Thank you for the opportunity to review and provide comments on the Open Water Surf Facility Modification Application to SSD-7942. In particular I welcome this opportunity because we weren't able to provide comments on the first application.

In regard to Sec 6.7 Water Quality in the Statement of Support for Section 4.55(2) Modification Application to SSD-7942 - the proponent will need to ensure that the facilities located within the surf park are designed so that they can be maintained in accordance with the Public Health Act 2010 and Regulation 2012 requirements for public swimming pools. Water chemistry and disinfection requirements for public swimming pools are listed in Schedule 1 of the Public Health Regulation 2012.

1 SECTION THROUGH POOL
SCALE 1:50

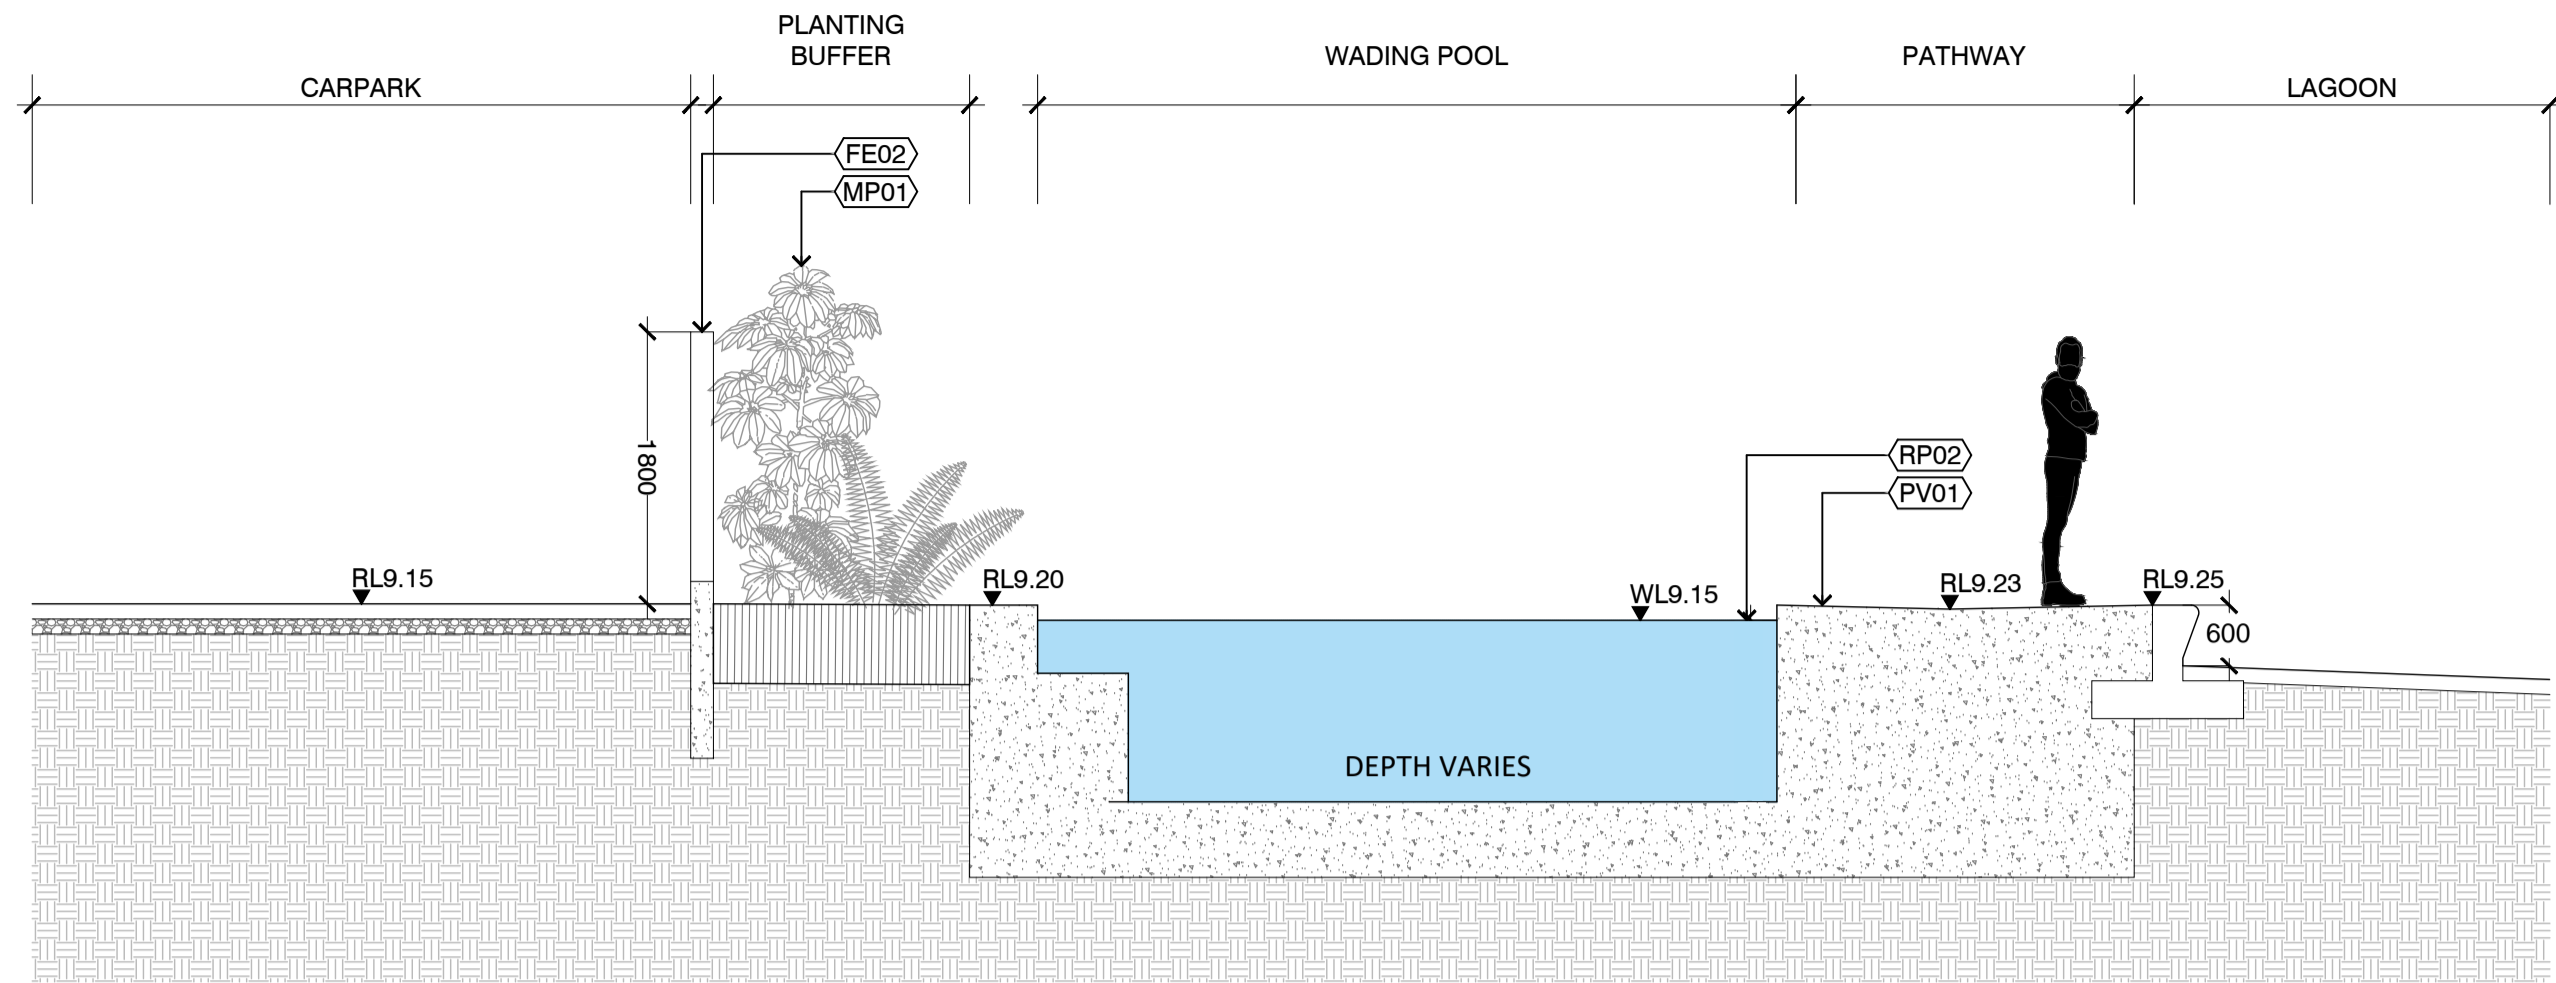
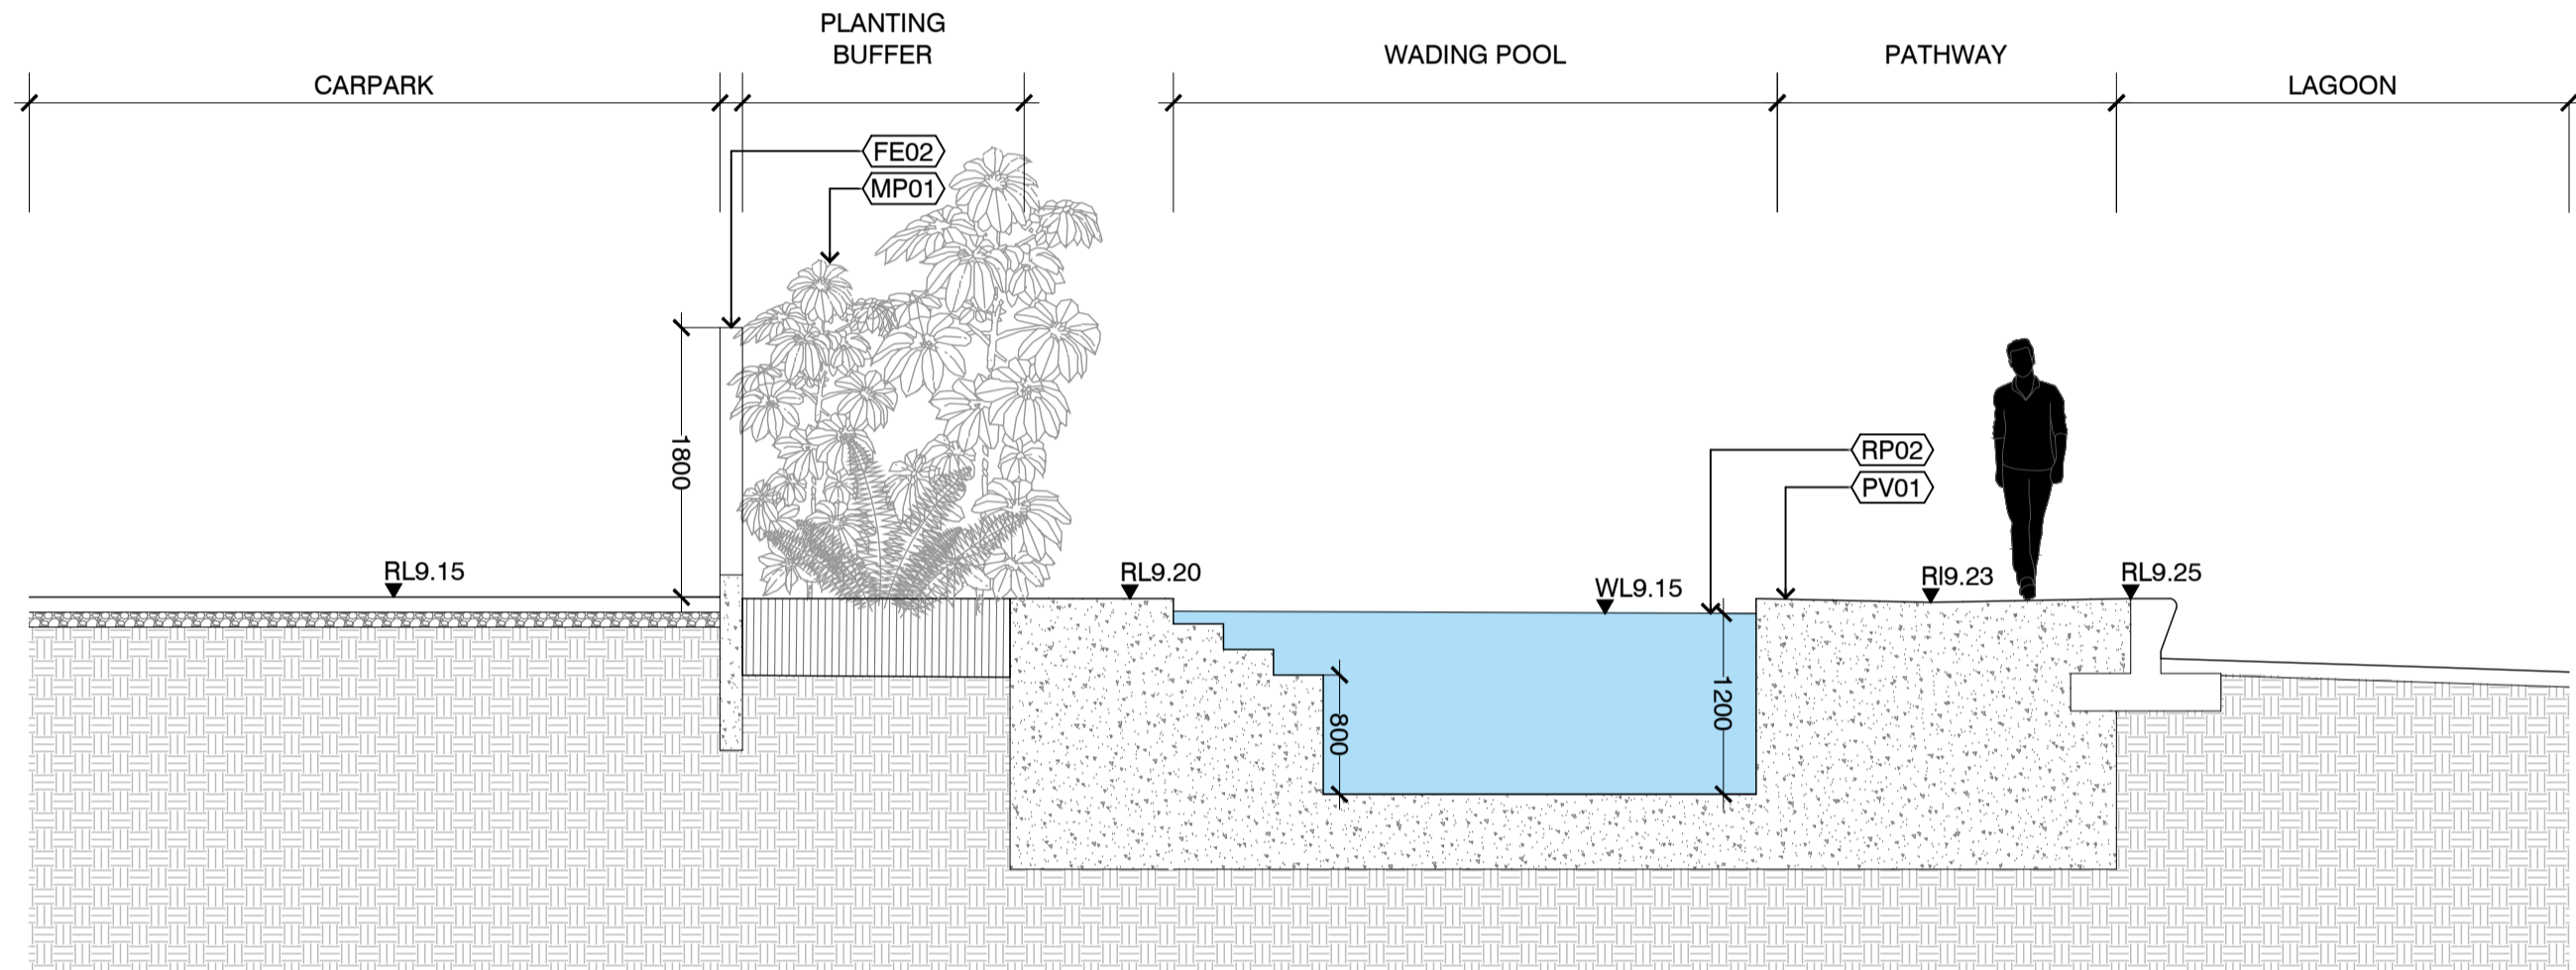
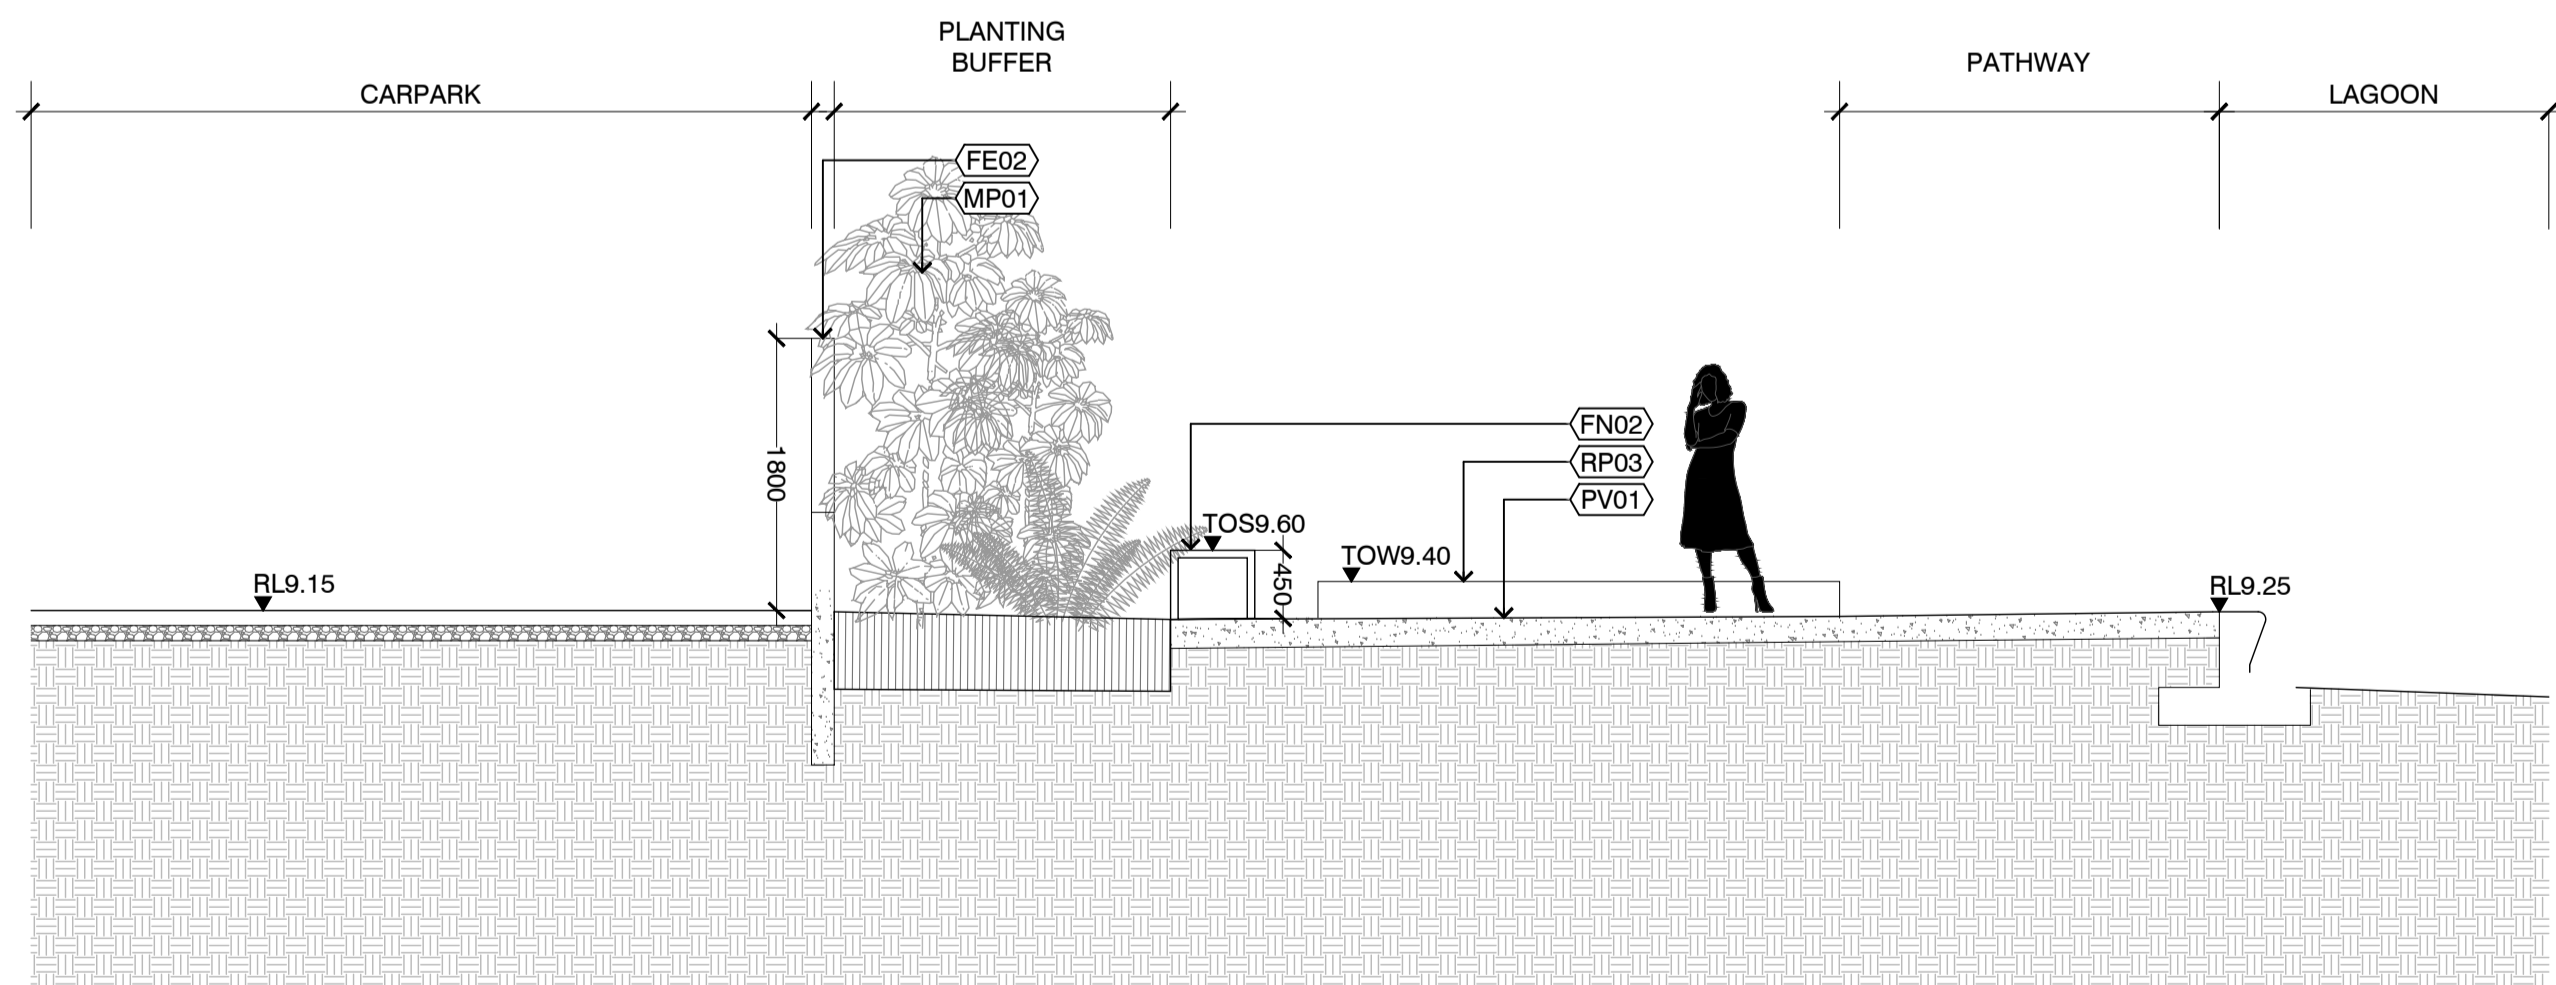
These requirements are extended not just to the wave pool lagoon but also to the rock pool (dependent on design/depth/water source), toddler pool, hot tub and splash zone along the south-eastern edge of the lagoon beach (as mentioned in 3.1.3 Modifications to the Lagoon and adjacent facilities.

It is strongly recommended that each 'pool' has its own separate circulation and disinfection system and that there is a connection to sewer for disposal of backwash water or other waste water in accordance with Sydney Water trade waste requirements.
